DECISION DELEGATED TO HEAD OF PLANNING

Application No: H15-0471-24 **Applicant:** Mr Therold
Proposal: Proposed Side Extension
Location: 16 Beck Bank Quadring Fen Spalding
Terminal Date: 30th July 2024

PROPOSED BLOCK PLAN

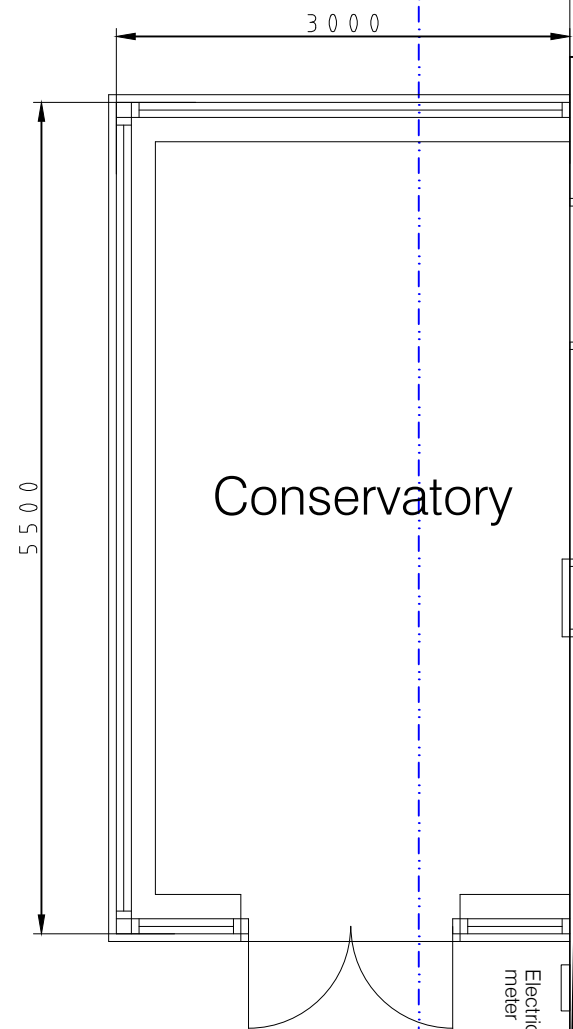
"The proposed block plan shows that the whole of the frontage will be parking but this isn't part of the proposal. Do the applicants intend on changing the frontage to parking as it currently mainly grass? If they do, they will need to extend the dropped crossing and this should be constructed to Lincolnshire County Council Specification. A note should be added to the proposed block plan detailing this."

The relevant consultee from the Highway Authority queried as to whether the parking arrangements would be altered as a result of the works. It has been confirmed by the applicant that the area to the front of the property will remain unchanged. No alterations are proposed to the access arrangements.
